34-36 Saunders St, Portland ME

Willett Duplex

RE: Saunders Street Subdivision
ID #2003-0022, CBL #130-F-021

TO: Kandi Talbot – Planner
FROM: Jim Seymour – Development Review Coordinator, Sebago Technics, Inc.
RE: 34 Saunders Street – Two-Family Home
DATE: February 28, 2003

RECORD OWNER:	DRAWN BY: JDM	PLAN DATE: 11/20/02
	CHECKED BY: TFB/DNL	SURVEY DATE: Oct. 2001
	INSTR: Topcon GTS-3B	SCALE: 1" = 80'
FIELD BOOK: FS 518 & Topcon PFC	JOB No: 200176	SHEET No: 1 of 1

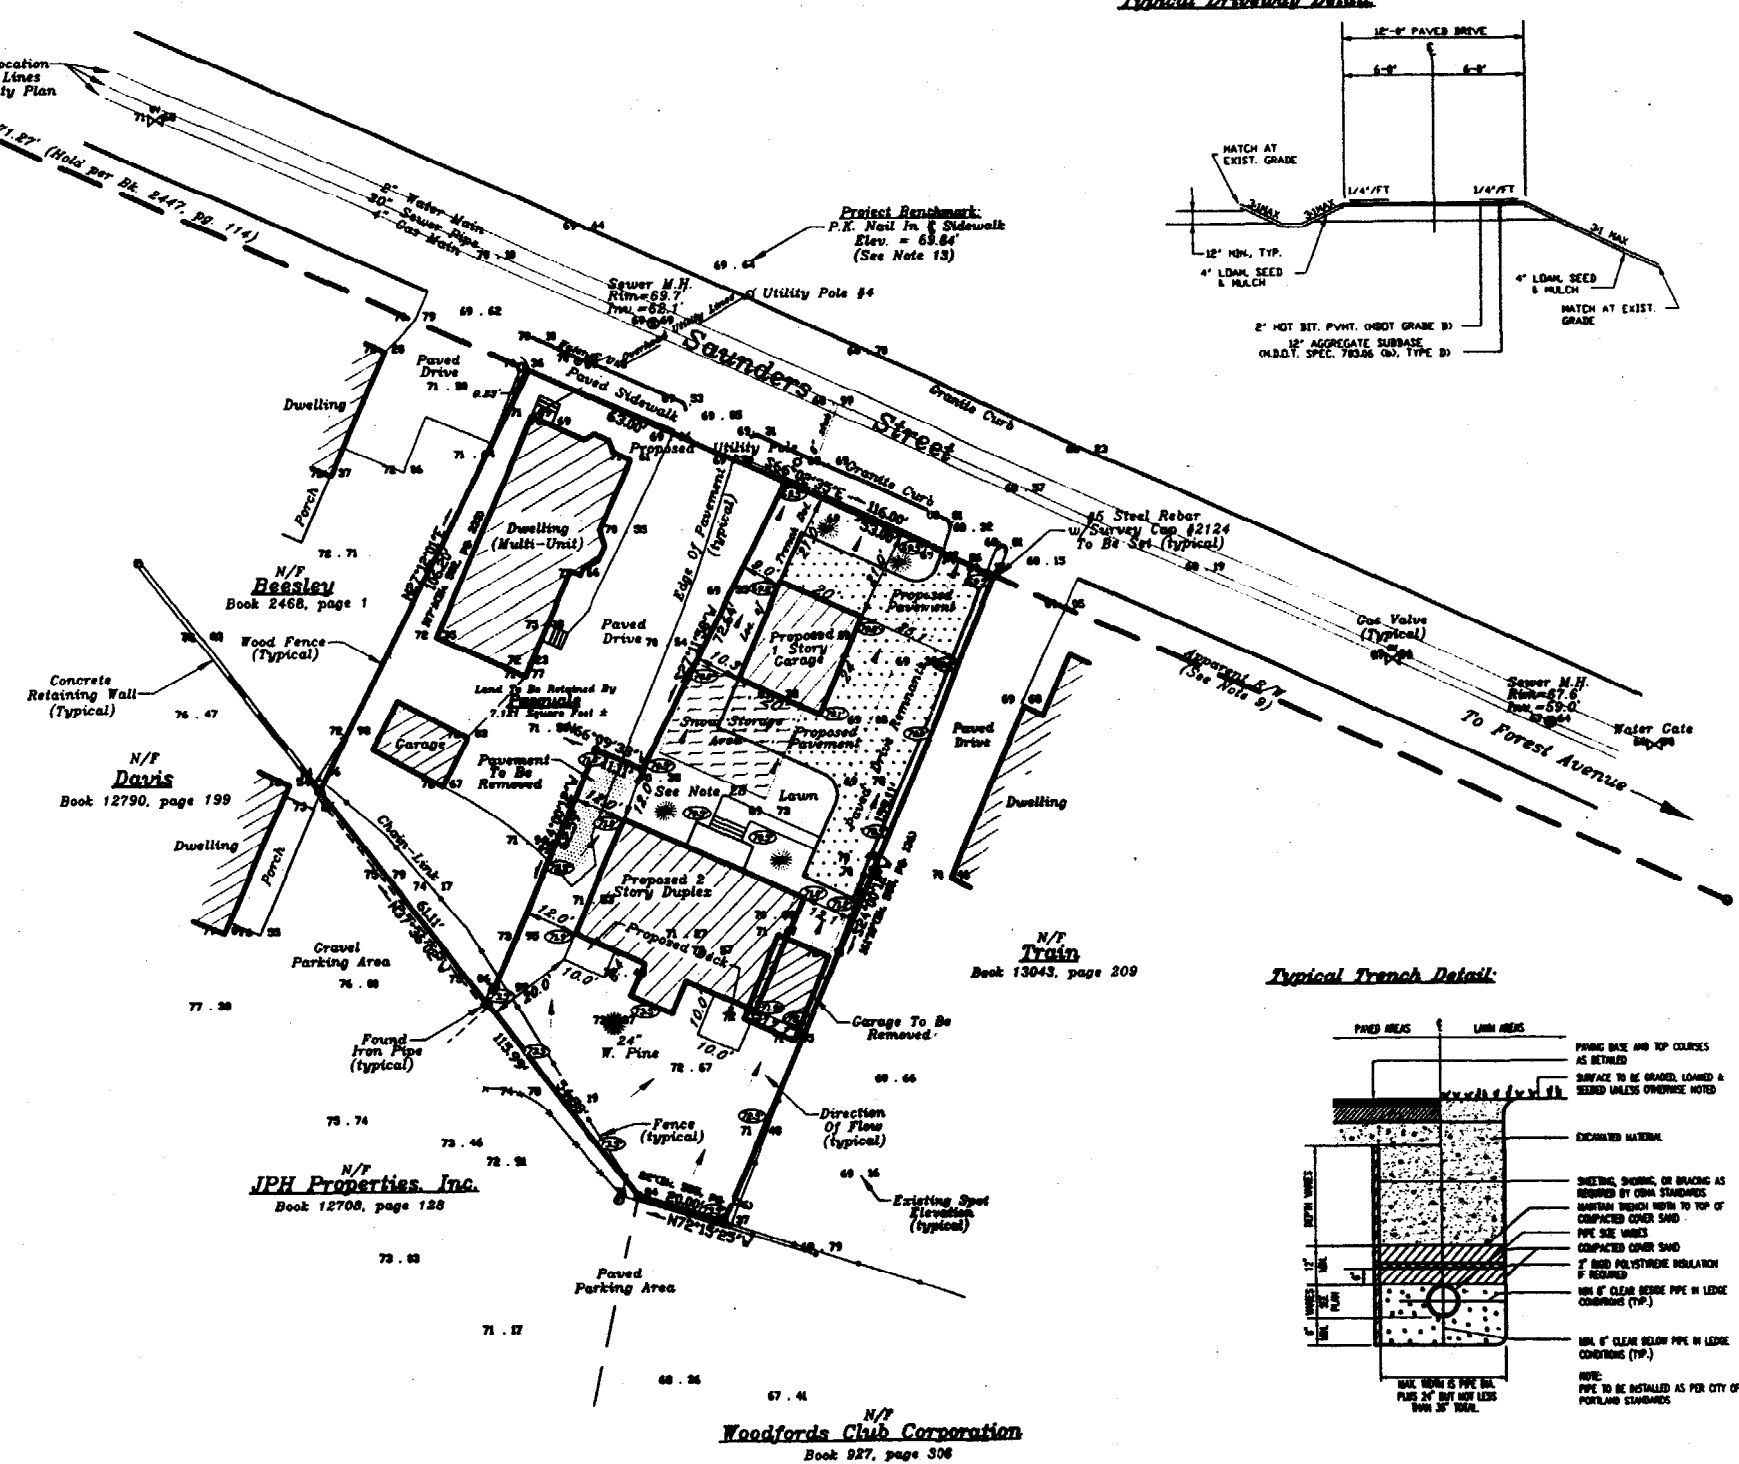
1. The plans need to specify proposed utility service connections, including natural gas, water and sanitary sewer.
2. The plans must also specify the anticipated utility trench excavations in Saunders Street.
3. The applicant needs to submit utility capacity letters as part of their applications, including a sanitary sewer capacity from Public Works Engineering.
4. The applicant is advised to contact Carol Merritt at Public Works to confirm the required permits and associated permit fees.

13. Is the applicant proposing to save the existing shrubs along the front at the sidewalk and between the proposed property and Train parcel abutting the easterly boundary of the project? Is so, a note should be added to protect these existing plantings as they provide an effective buffer.

14. Is any landscaping being provided? A total of four (4) trees are required and must be existing trees to be saved or meet City specifications for new trees.

15. As a result of the subdivision of the property, do both parcels have adequate area for snow storage? The snow storage areas should be designated on the plan for each lot? The concern is with how snowmelt in areas apparently available for snow storage, will effect neighboring properties. A note may be needed stating that excessive amounts of snow (banks or piles over 4 feet in average height) will be removed by contractor.

16. Will blasting of ledge be required to install the building foundations or utility trenches?
17. Need to provide typical details for the following: driveway pavement buildup section, sidewalk section, utility trench, and granite curb. A detail or note should be provided on the plan describing the proposed ground treatment.

18. Appropriate BMP details shall be included on the detail plan sheet.
19. The applicant must submit right, title and interest.
20. The applicant must submit evidence of financial and technical capability to undertake and complete the development including a letter from a responsible financial institution stating that it has reviewed the planned development and would seriously consider financing it when approved.

Care must be taken not to direct any additional stormwater runoff onto adjacent properties as a result of the proposed project being constructed. Careful placement of roof drain downspouts and site spot grades will need to be considered.

A. Provide inlet protection for catch basin in Saunders Street. Is there a catch basin located in Saunders Street in front of the project? (Note: Street was snow/ice covered during the time of the field visit.)

B. Appropriate BMPs will need to be shown installed on the plan.

C. Although the spot grades can be useful the plan will be more beneficial if contour lines can be provided in 1 foot or two foot intervals. Spot grades are useful if the ones shown represent finish grades in areas where drainage is of concern or elevation is critical in relation to the existing or proposed structure.

- A. Letters must be obtained from utilities stating that adequate capacity exists.
- B. Existing utility information, such as inverts for sewer manholes, pipes and stubs and approximate locations of sewer stub, water and gas mains should be shown on appropriate plan sheets, along with proposed building utility service run locations.
- C. Will all utility services be installed underground?
- D. Is the applicant proposing to provide electric service from utility pole #4 shown on the survey plan?

- A. According to Nadeau and Lodge Survey note number 13, the plan elevations are based on an assumed datum. Care should be taken, especially with the sewer service design, to determine the appropriate adjustment factor necessary to accurately compare project elevations to existing sewer infrastructure elevations.

- B. Is the applicant proposing to save the existing shrubs along the front at the sidewalk and between the proposed property and Train parcel abutting the easterly boundary of the project? If so, a note should be added to protect these existing plantings as they provide an effective buffer.

- C. Is any landscaping being provided? A total of (4) four trees are required and must be existing trees to be saved or meet City specifications for new trees.

- D. As a result of the subdivision of the property, do both parcels have adequate area for snow storage? The snow storage areas should be designated on the plan for each lot? The concern is with how snowmelt in areas apparently available for snow storage, will effect neighboring properties. A note may be needed stating that excessive amounts of snow (banks or piles over 4 feet in avg.height) will be removed by contractor

- E. Will blasting of ledge be required to install the building foundations or utility trenches?

- A. Need to provide typical details for the following: driveway pavement buildup section, sidewalk section, utility trench, and granite curb. A detail or note should be provided on the plan describing the proposed ground treatment
- B. Appropriate BMP details shall be included on the detail plan sheet.
